DECISION DELEGATED TO DEVELOPMENT MANAGER

Application No: H16-0940-18 **Applicant:** Miss Gemma Louth
Proposal: Proposed bay window and internal alterations
Location: 30 Thistle Gardens Spalding
Terminal Date: 19th November 2018

SHEET
**Proposed Floorplan,
Proposed Elevations
Block Plan**

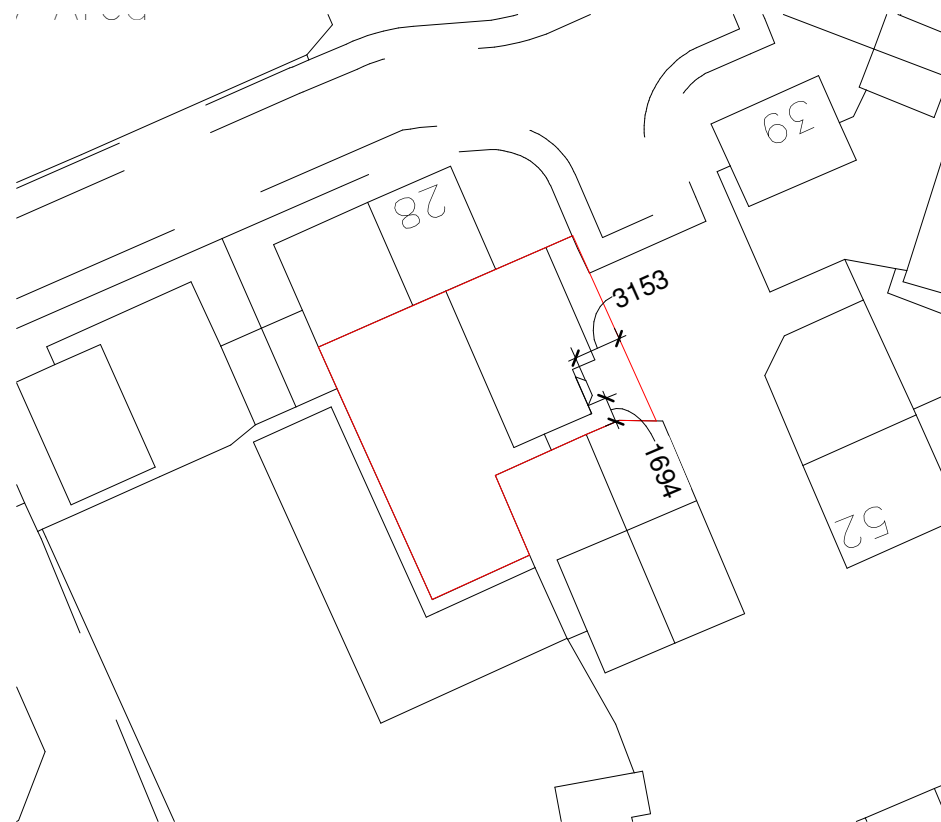
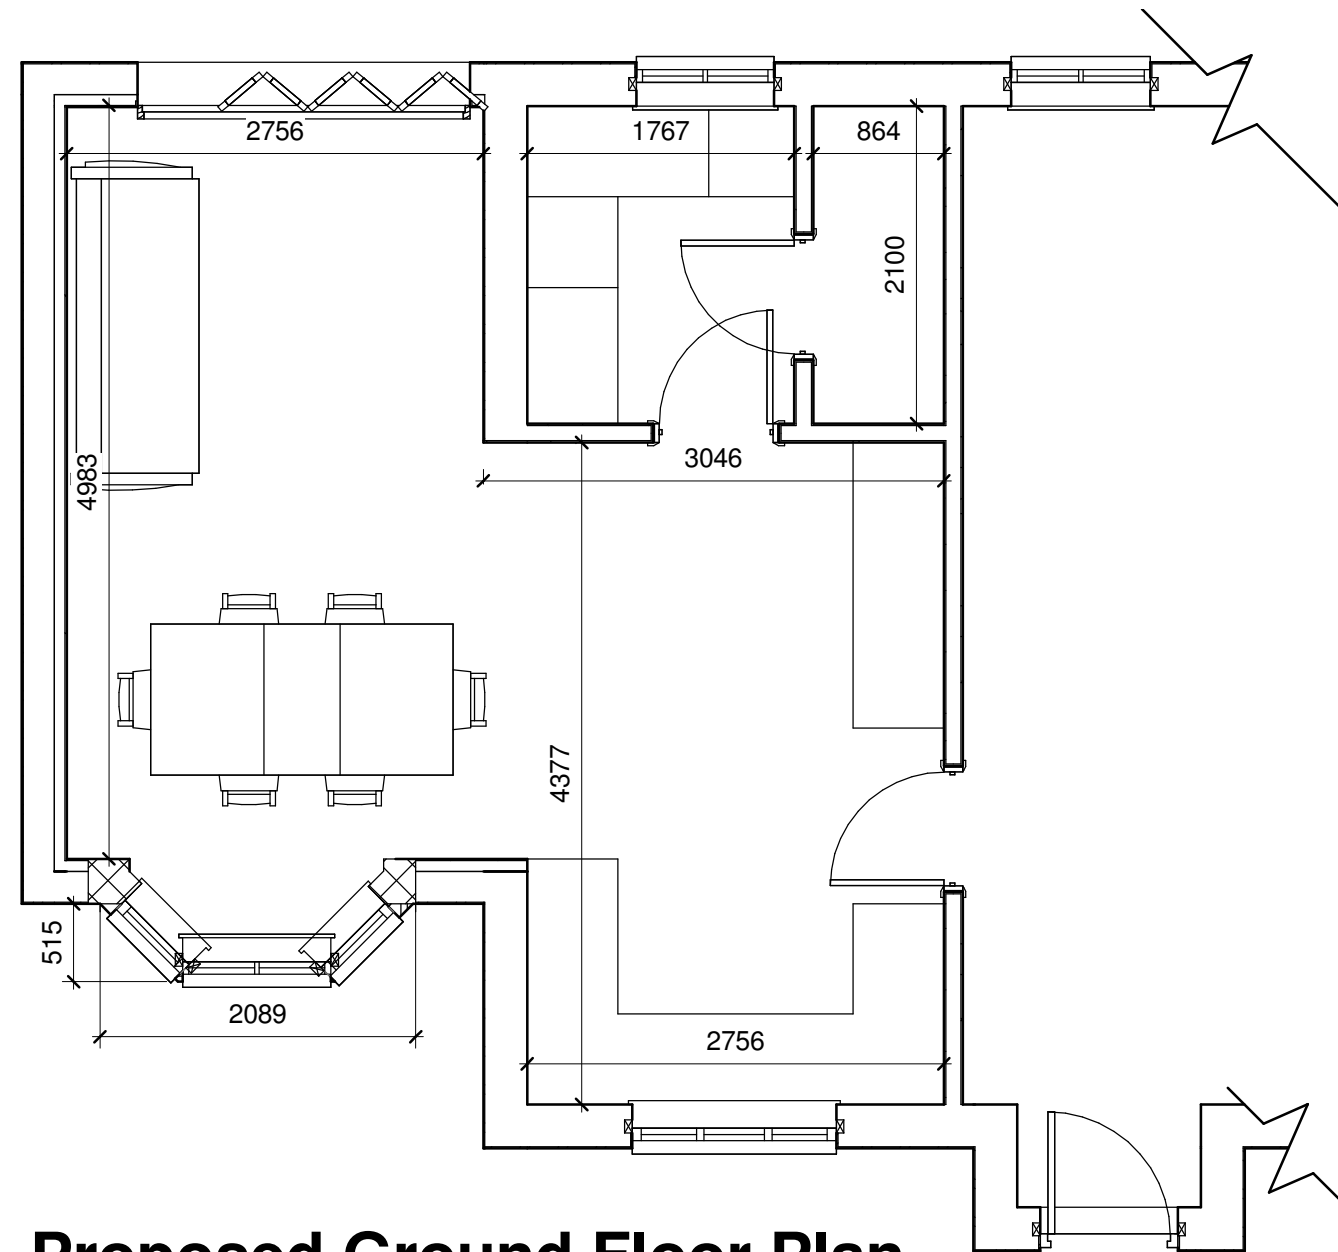
The garage door would be replaced for proposed bay window which would protrude 0.51 metres

from the principal elevation and would be 2.08 metre wide. This window would mirror the existing bay window opposite elevation end although it would not have a hipped roof but flat roof to fit the lower garage eaves. At the rear elevation, the bi-fold doors and adjacent window would be replaced for brick wall and single panel door respectively.

External alterations are accordingly made to internal alterations. An internal wall would be demolished to convert both existing kitchen and garage into one large combined dining/living room. The proposed materials would match those existing in the dwelling.

The bay window would be keeping with the character of the house and would not be detrimental to the local area. Further bay windows and canopy roofs of a certain range of designs and appearances have been observed in properties nearby.

Other external alterations would not represent an adverse impact upon the appearance of the property. The proposals for internal layout are acceptable given the living needs of the dwelling occupiers.

No impact upon the residential amenity of adjacent residents is anticipated after carrying out the proposed development.

It is accordingly recommended to approve this planning application via delegated decision.
